Quality Audit Report

Athlone Link Road Phase 2 – Coosan Point to The Crescent

On behalf of **Westmeath County Council**

May 2025

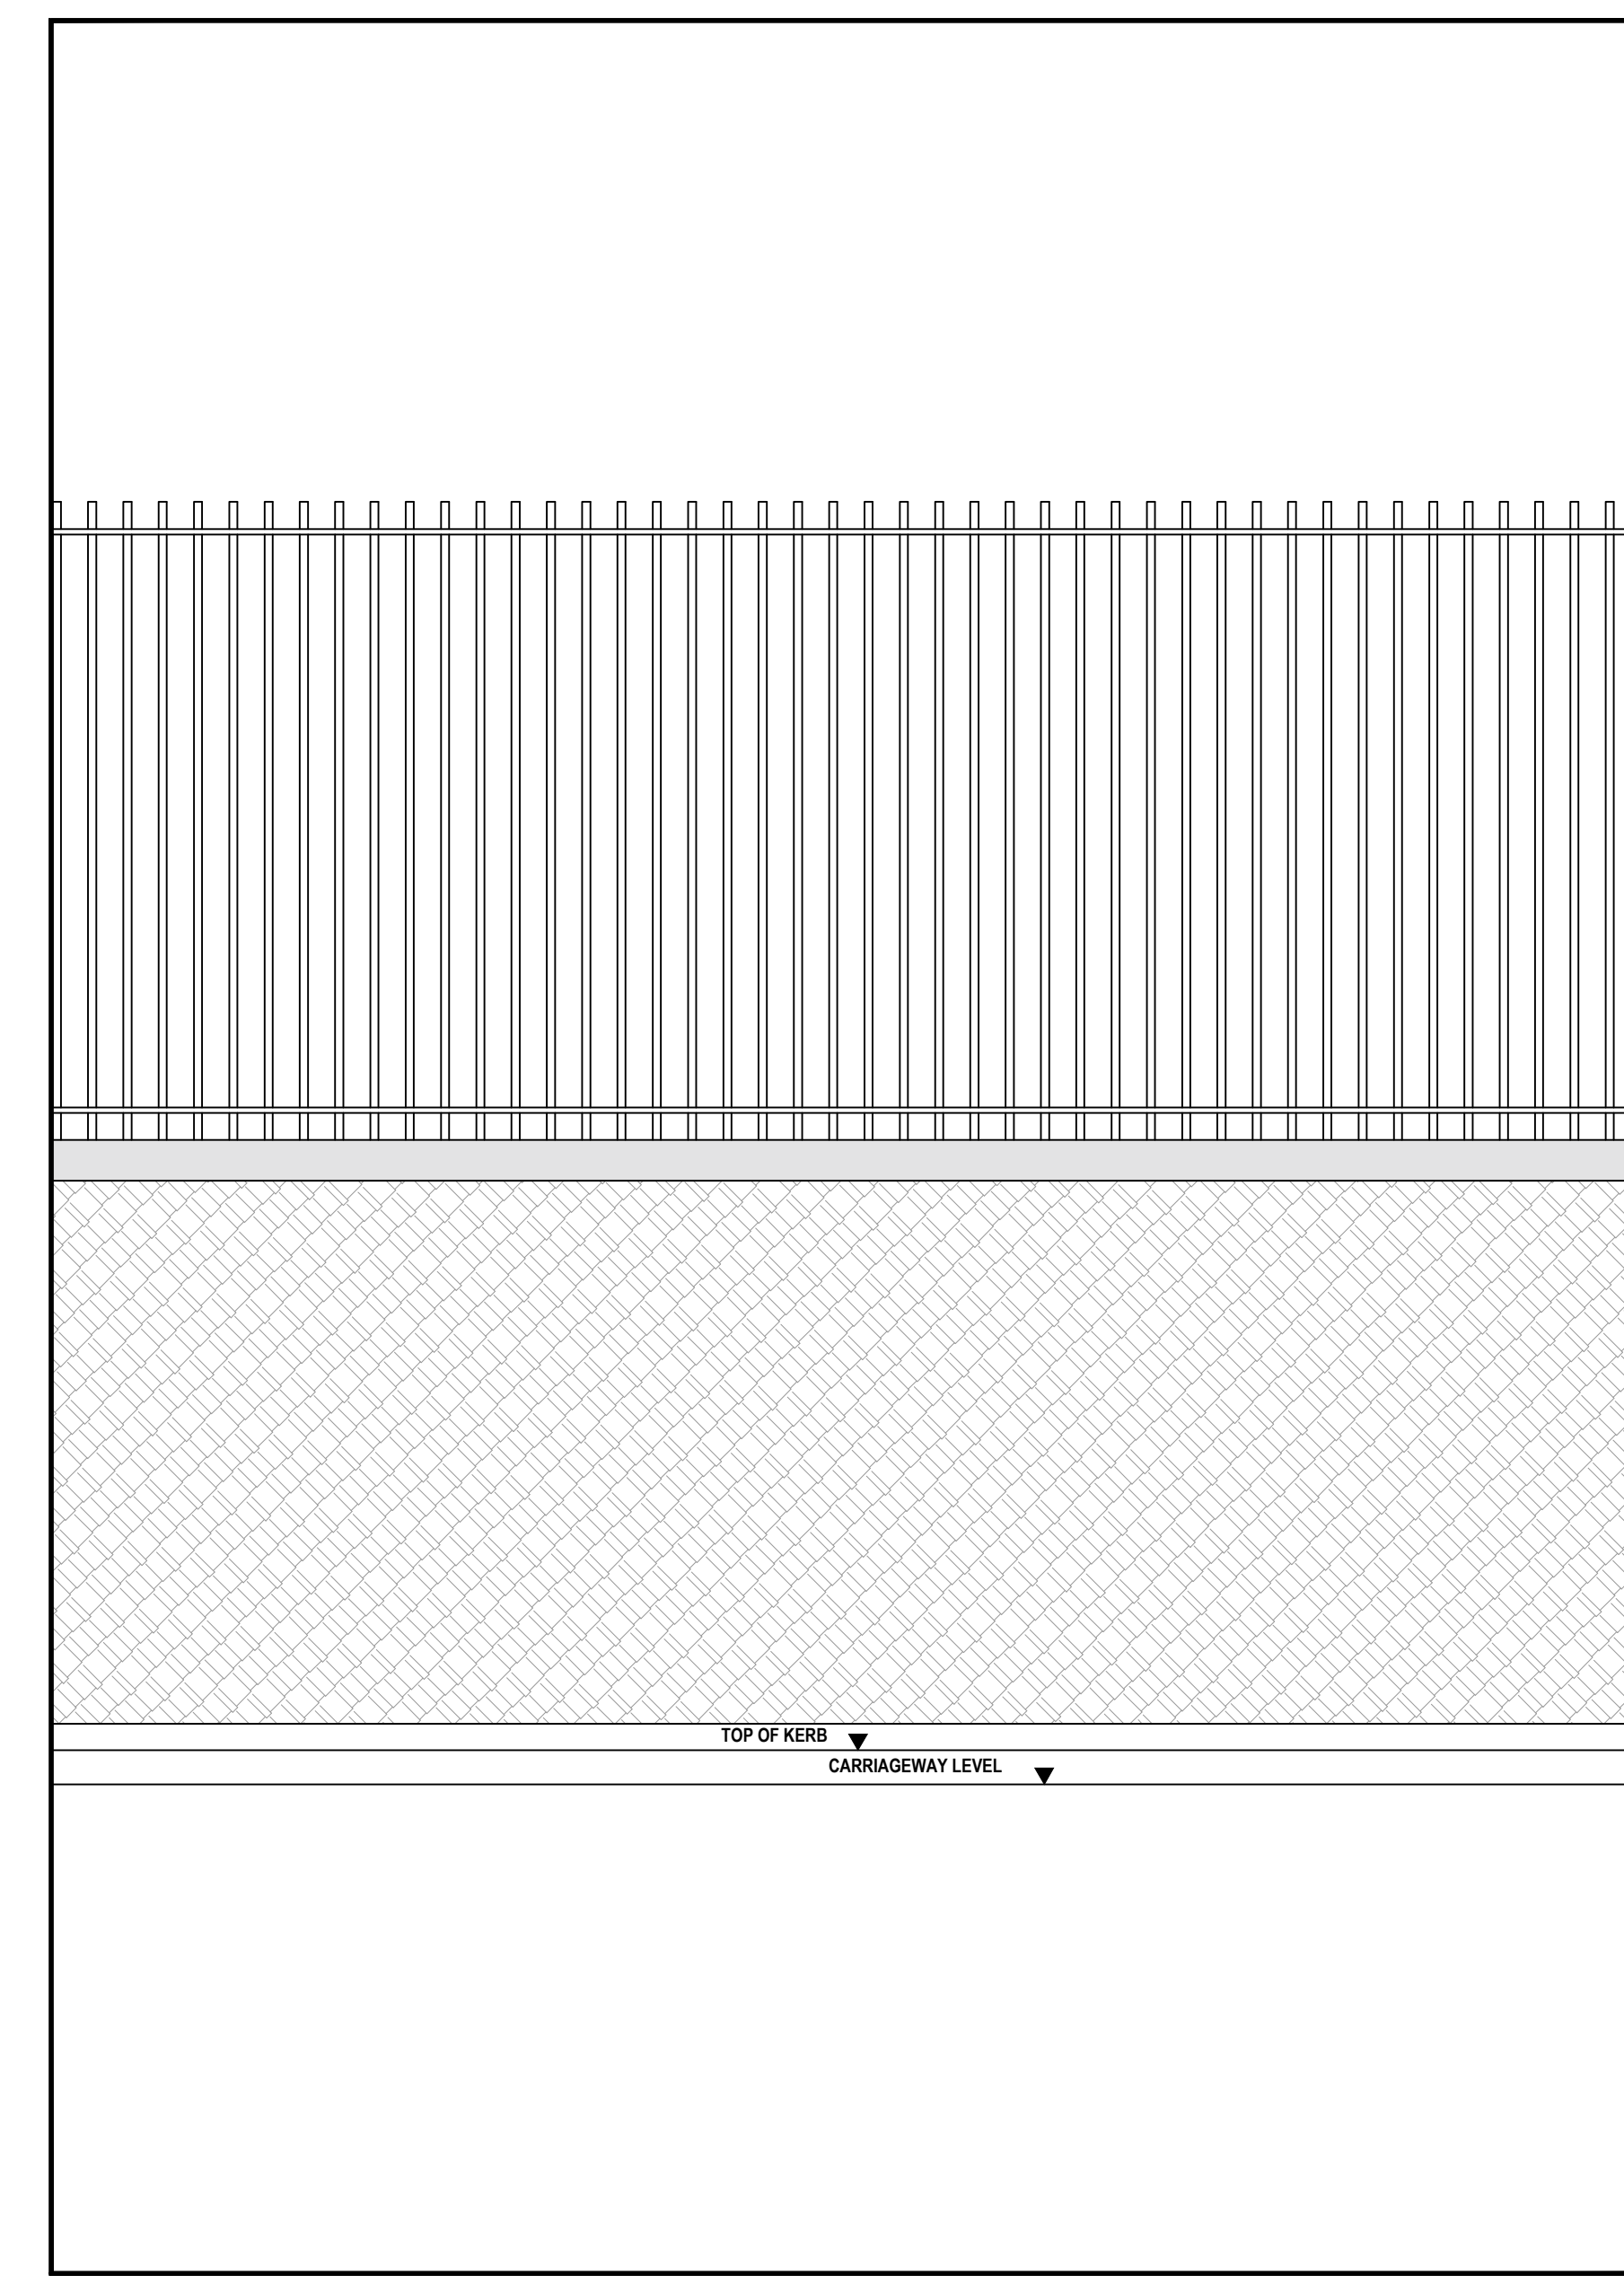
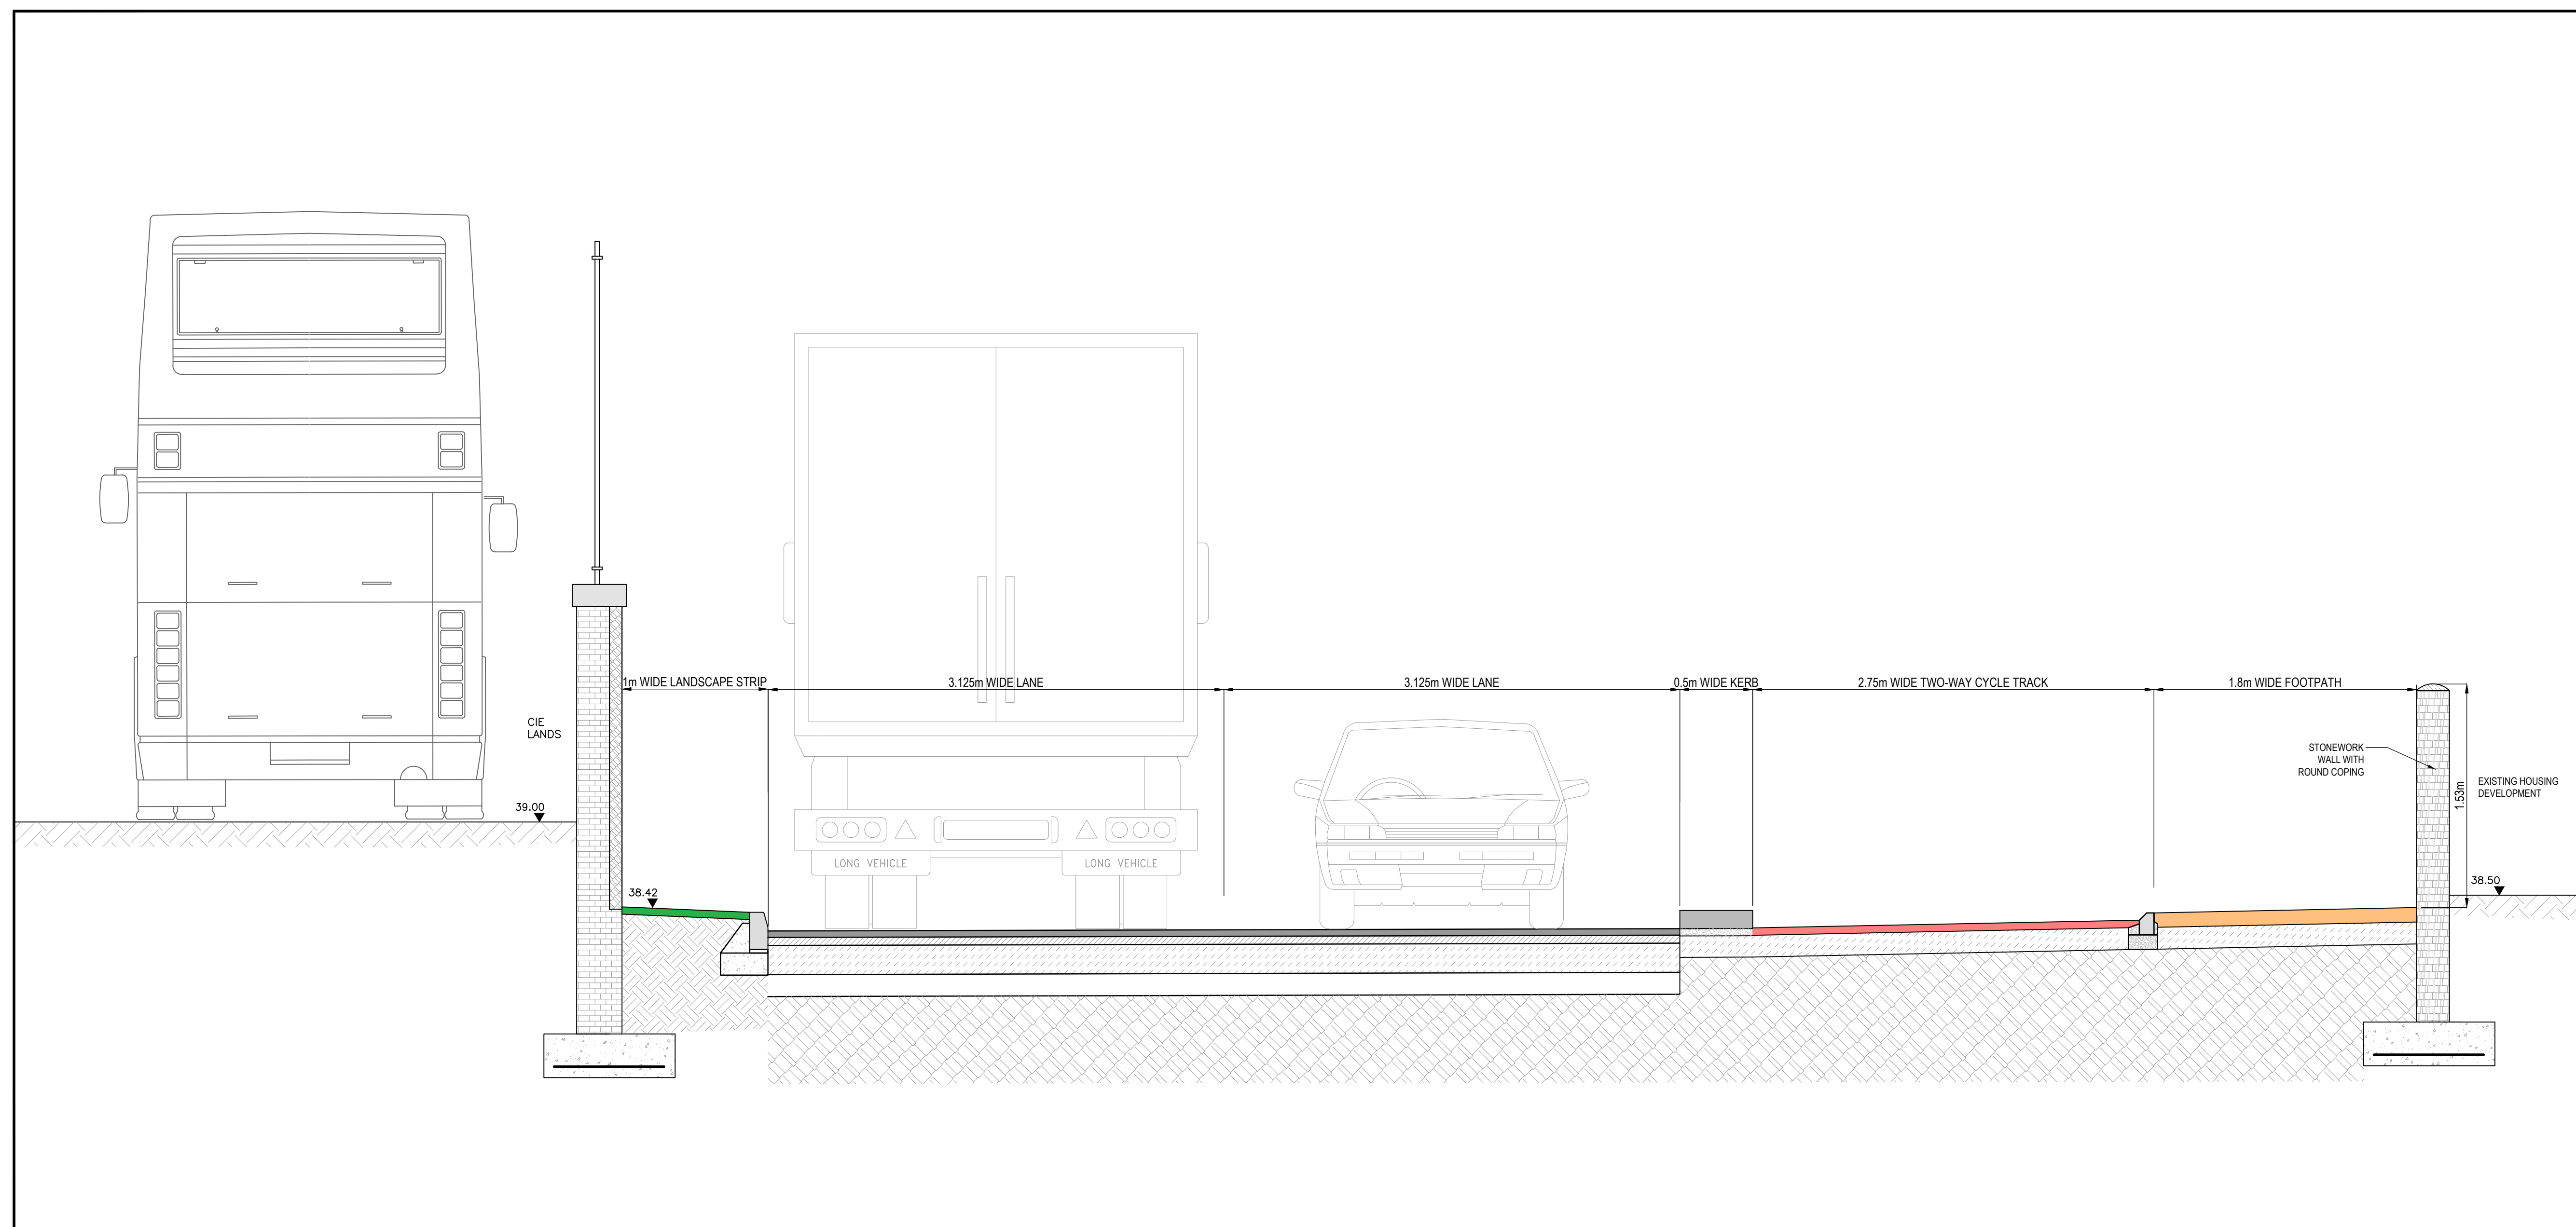
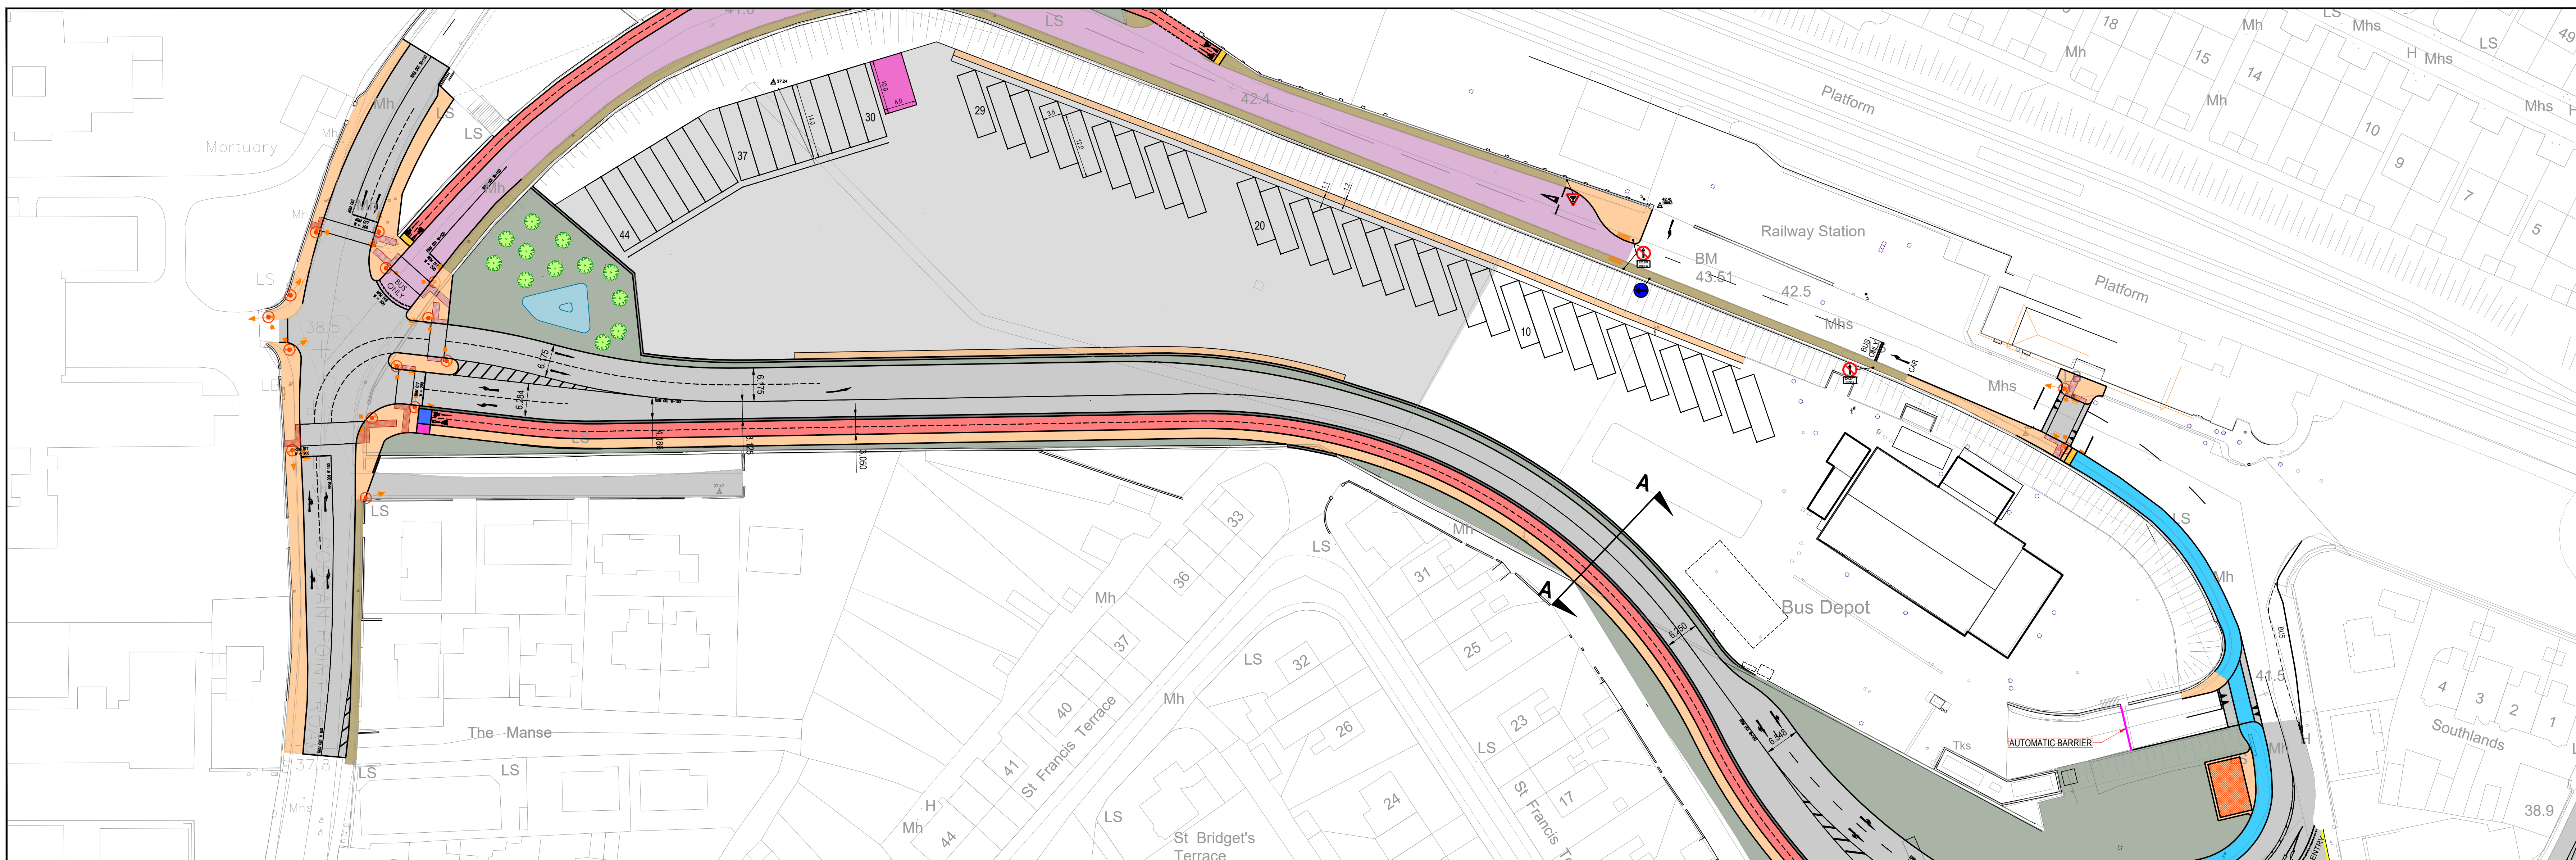
| Ref | Feature | Conforms | Access Comment | Action |
|-------|---|------------------------------------|--|---|
| 2.2.1 | Are the footpaths a minimum width of 1.5m (1.8-2.0m in high volume areas)? | Yes. New Link Road | The proposed cross-section for the new link road indicates a 1.8m wide footpath. | None |
| | | Unknown. Southern Station Road | The existing footpath along the southern side of Southern Station Road is indicated to be upgraded, but no dimensions are given. It appears that the existing footpath is narrow in places. | Designer to detail footpaths to appropriate width. 1.8m minimum is recommended. |

| Ref | Feature | Conforms | Access Comment | Action |
|-------|---|---|---|--|
| 3.1.2 | Are the footpaths of adequate width to cater for expected pedestrian numbers? | Unknown | <p>The proposed cross-section for the new link road indicates a 1.8m wide footpath.</p> <p>The existing footpath along the southern side of Southern Station Road is indicated to be upgraded, but no dimensions are given. It appears that the existing footpath is narrow in places.</p> | <p>Designer to detail footpaths to appropriate width. 1.8m minimum is recommended.</p> |

TACTILE PAVING AT CONTROLLED/ UNCONTROLLED  
PEDESTRIAN CROSSING

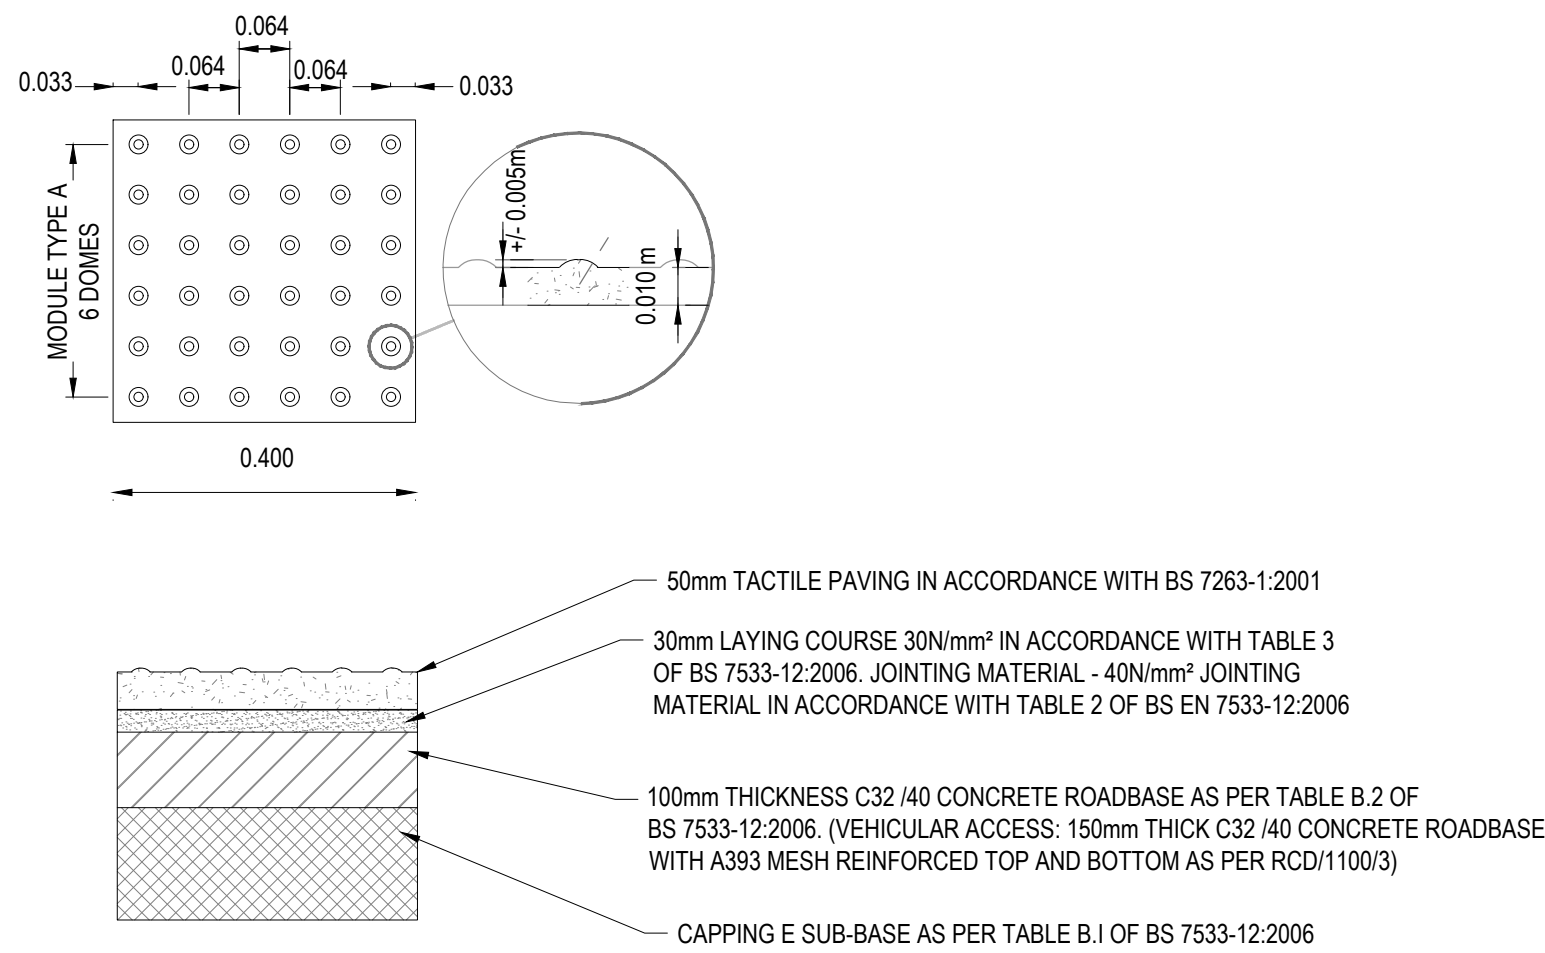
| Ref | Feature | Conforms | Access Comment | Action |
|--------|--|--------------------------------|--|---|
| 2.2.14 | Is suitable tactile surfacing provided at all pedestrian crossing locations? | Generally yes. | <p>The drawings do indicate/ imply dropped kerbs and associated tactile paving at pedestrian crossing points.</p> <p>However, no tactile paving is indicated at the bus depot access. Given that the proposed layout appears to be an access junction (not a vehicular crossing of a footpath) tactile paving is likely to be appropriate.</p> | <p>To be taken into account at detailed design.</p> <p>Details for the bus depot access should be reviewed.</p> |

| Ref | Feature | Conforms | Access Comment | Action |
|---|---|---------------|--|---|
| 2.4.3 | Are the kerbs lowered to form a dished kerb approach gradient no greater than 1:12 and an upstand above road level no greater than 6mm? | Unknown | The construction detail drawings specify kerbs 0 – 6mm at crossing points, but the footway gradient crossfall is not specified. However there does not appear any reason that acceptable crossfall gradients cannot be achieved through careful detailing. | To be taken into account at detailed design. |

| Ref | Feature | Conforms | Access Comment | Action |
|-------------------------------|---|----------|--|---|
| 2.4.7 | Does the crossing have tactile paving in compliance with the standards and in buff colour? | No | Further to 2.2.14, no tactile paving is indicated at the bus depot access. Given that the proposed layout appears to be an access junction (not a vehicular crossing of a footpath) tactile paving is likely to be appropriate. | To be taken into account at detailed design. Details for the bus depot access should be reviewed. |
